11 February 2013

File No: S076158
Our Ref : 2013/021003-01

RE: Section 75W request to modify the approved Project Application (MP11_0090 MOD 1) for Student Accommodation on Blocks 3B, 3C & 10 at Central Park, Chippendale (former Carlton United Brewery site)

DRAWING NO	
												A-406

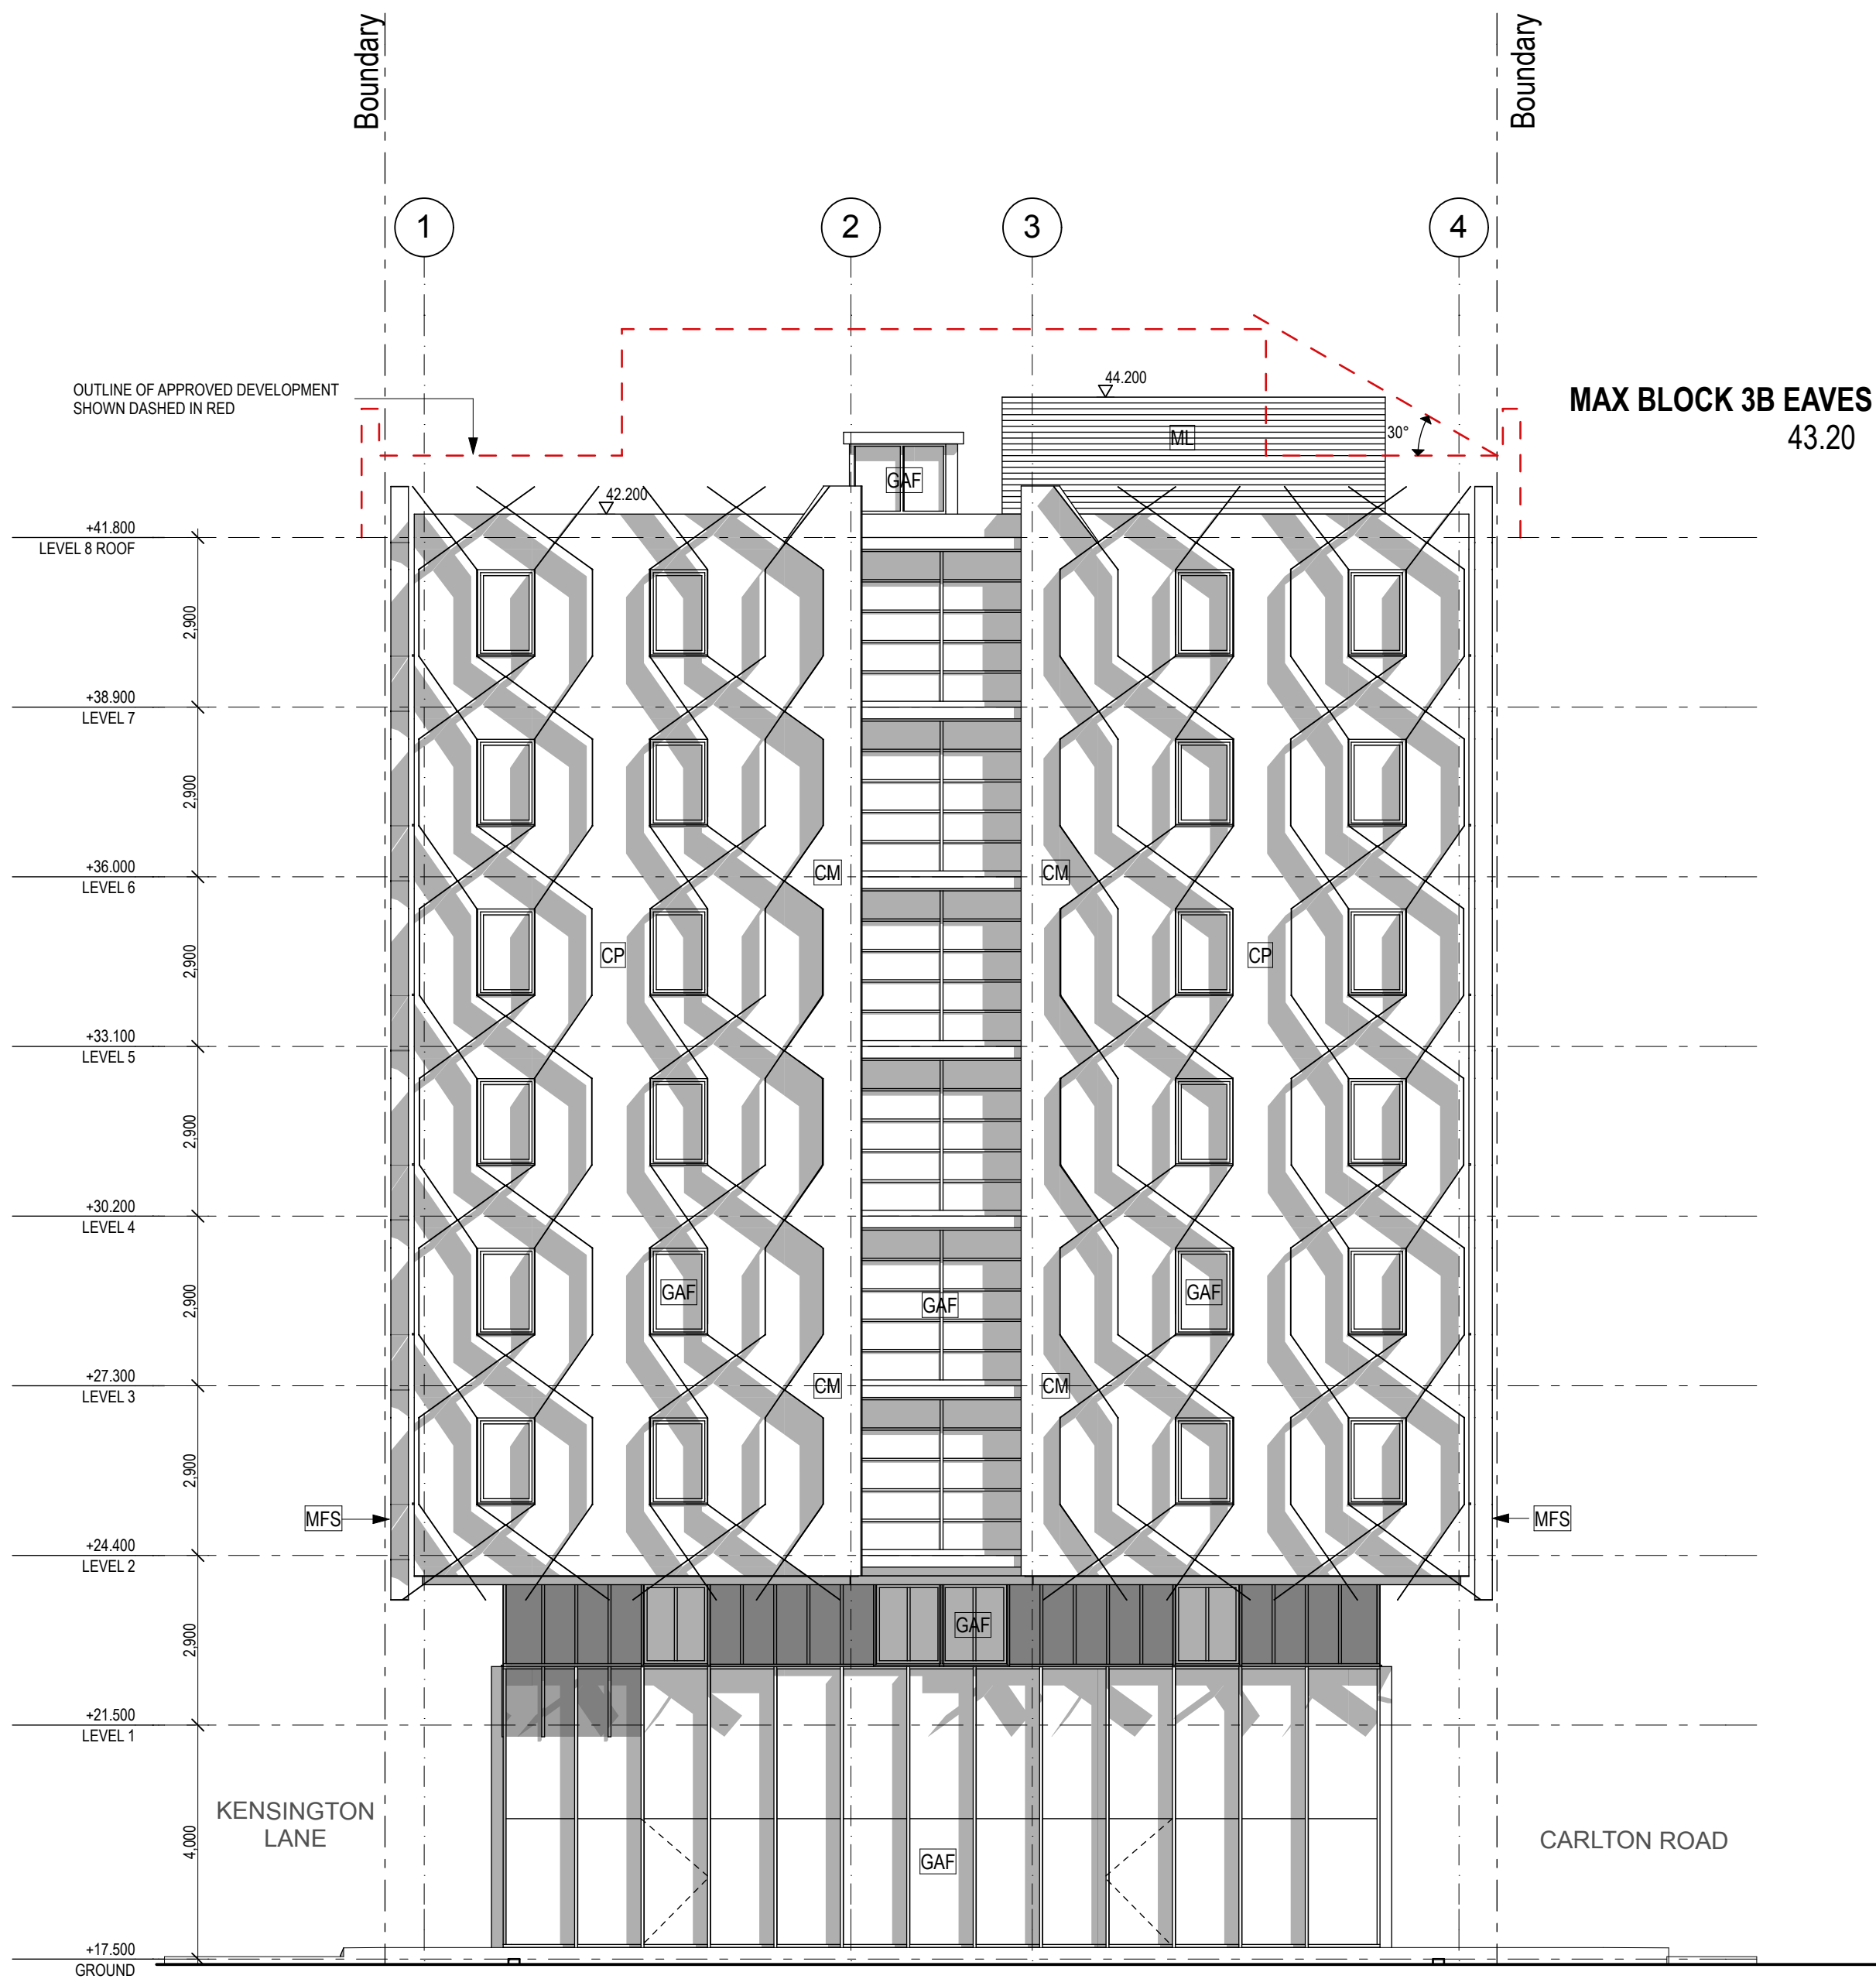
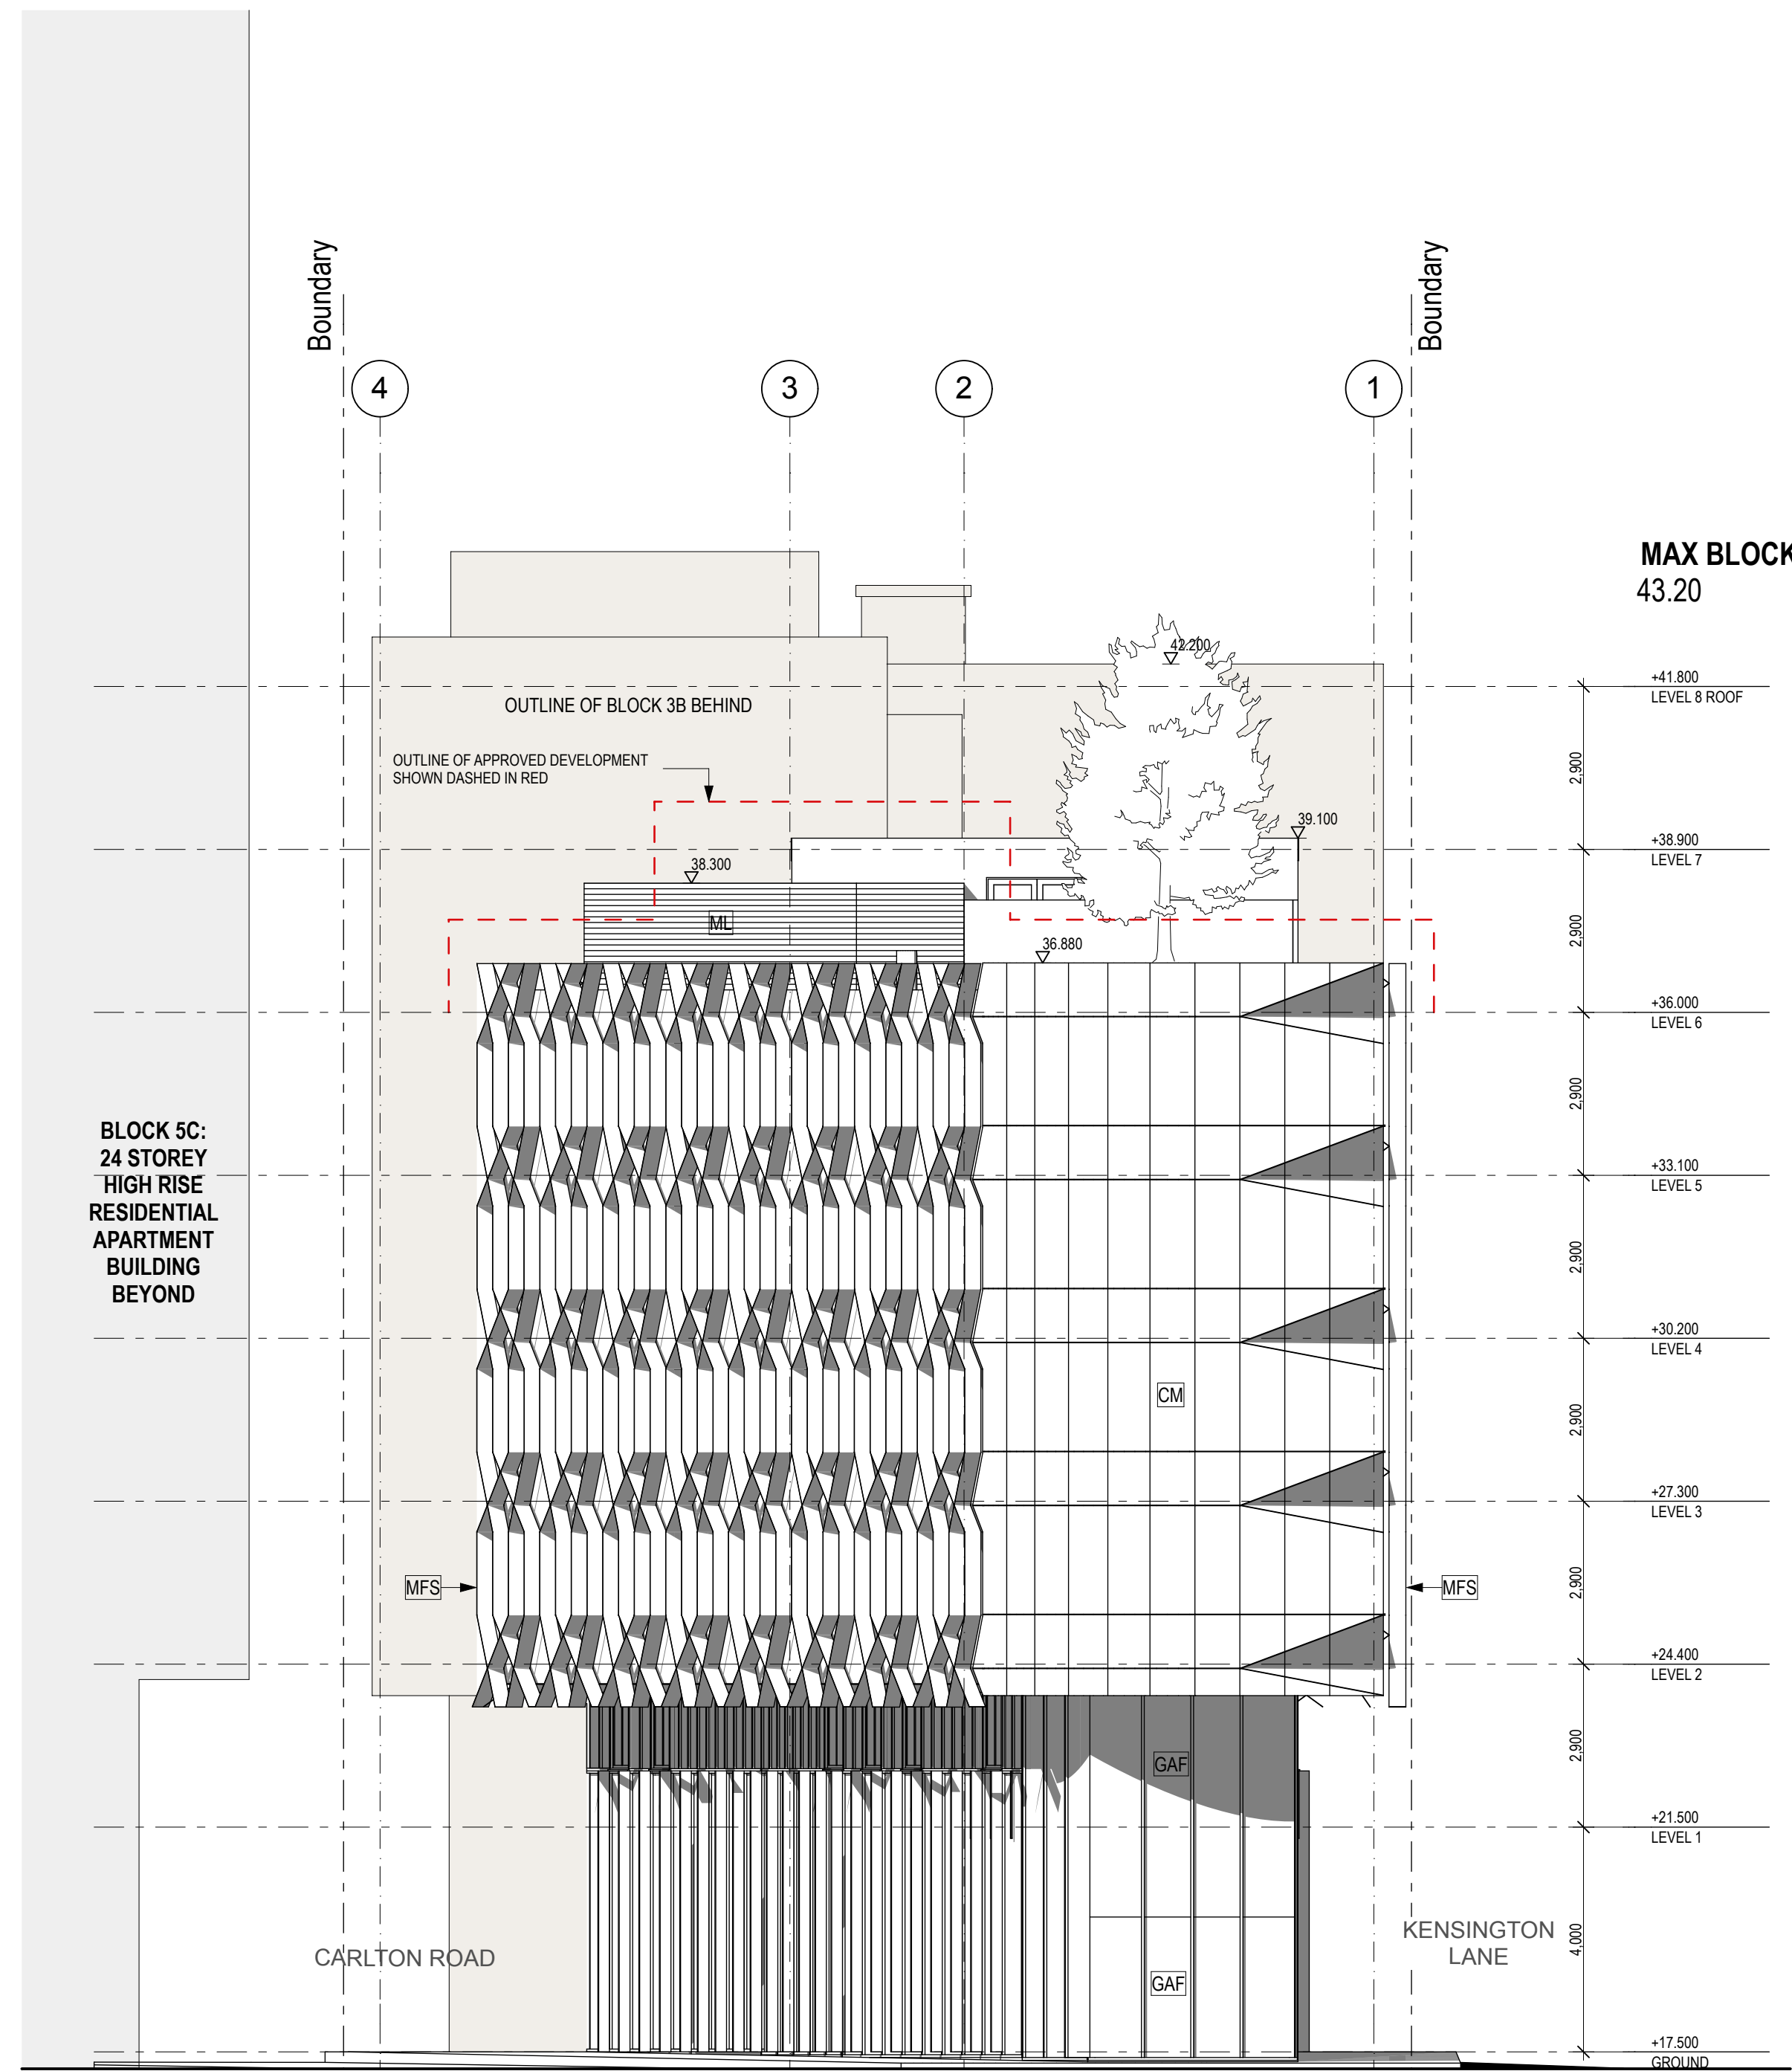
- Access to the student accommodation on Level 1 of Block 3C from the public domain is limited to the fire stair ("Stair 2") fronting Carlton Street. From the Carlton Street elevation, Stair 2 is not identified as an entry point for student accommodation in Block 3C. The door to Stair 2 is finished with metal louvred doors matching the external finish of other service/plant areas on the ground level. In this regard, the proposed access to Level 1 is not acceptable and should be modified so that a separate and clearly distinguished entry for the student accommodation use is provided at street level.

- (a) A designated entry to the student accommodation use on Levels 1 to 5 in Block 3C is to be provided on the ground level.
- (b) Laundry facilities should be provided in both Blocks 3B and 3C, and Block 10. Washing machines and dryers are to be provided in accordance with Condition E9(a) and (b) of the Project Approval.

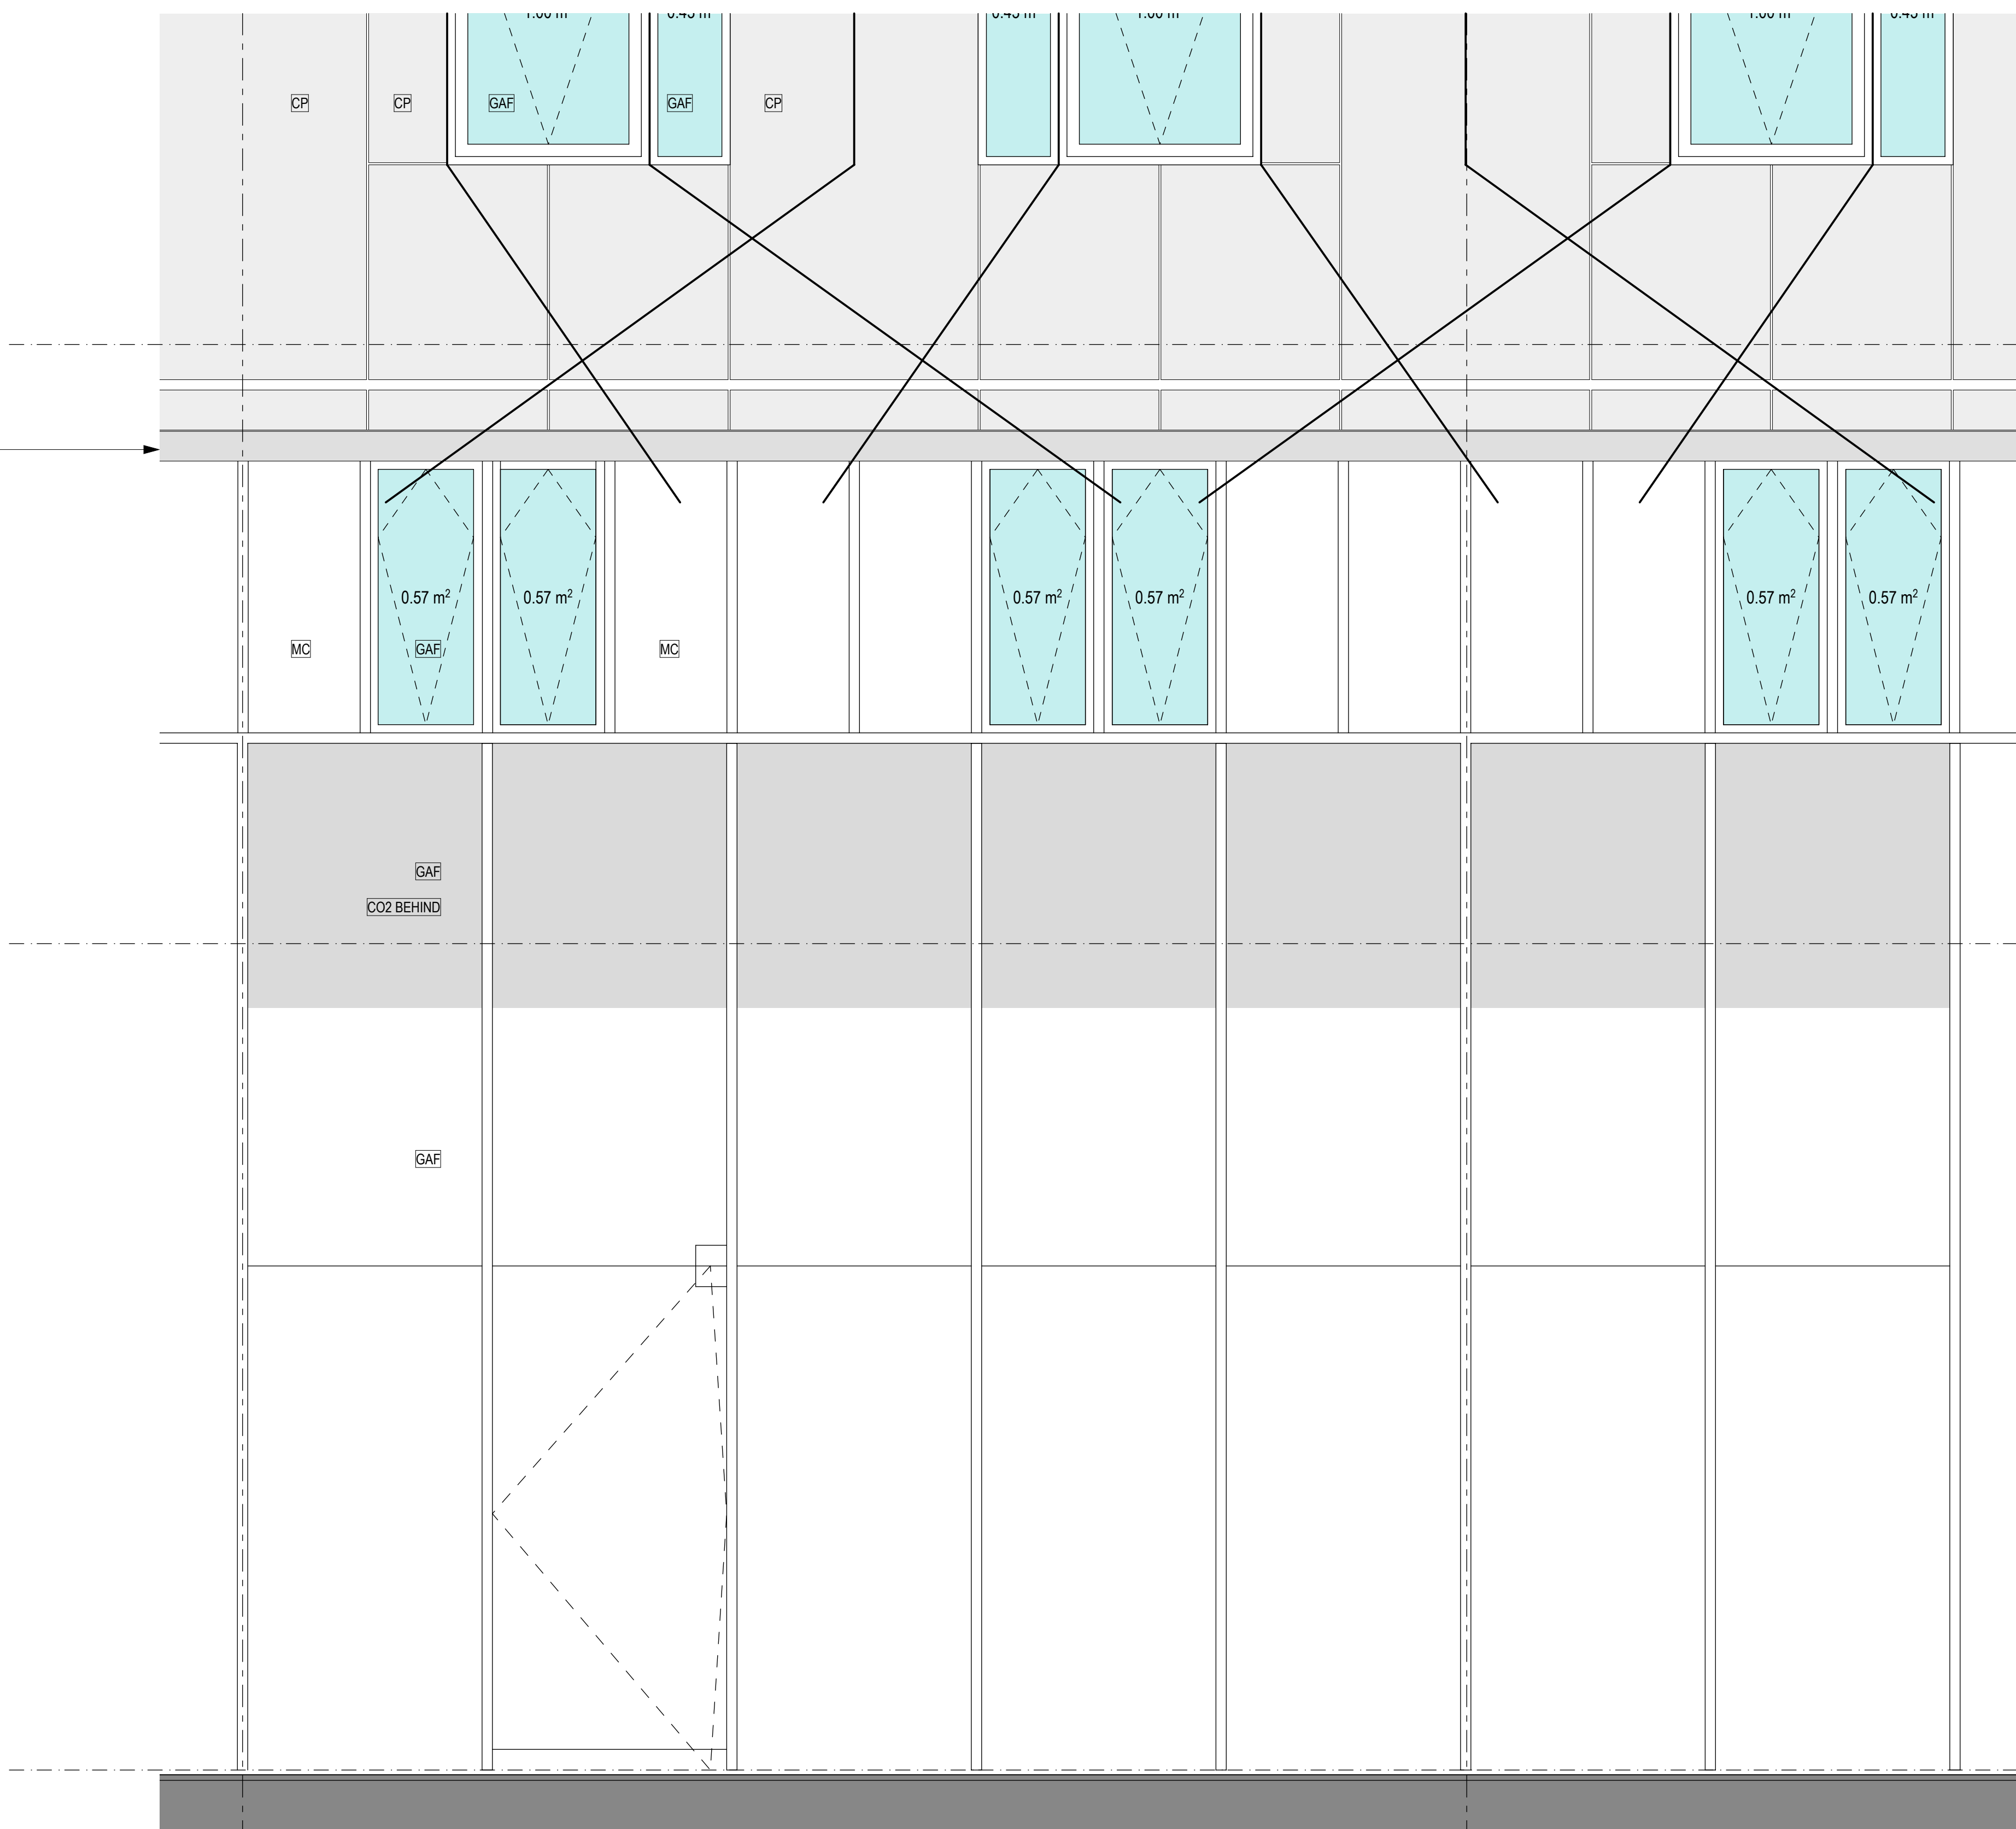
The proposal to replace cement walls with fibre cement cladding is generally acceptable, subject to the cladding matching the external finishes noted in Drawing Number A-3506 Revision A, prepared by Tokin Zulaikha Greer Architects, dated December 2012.
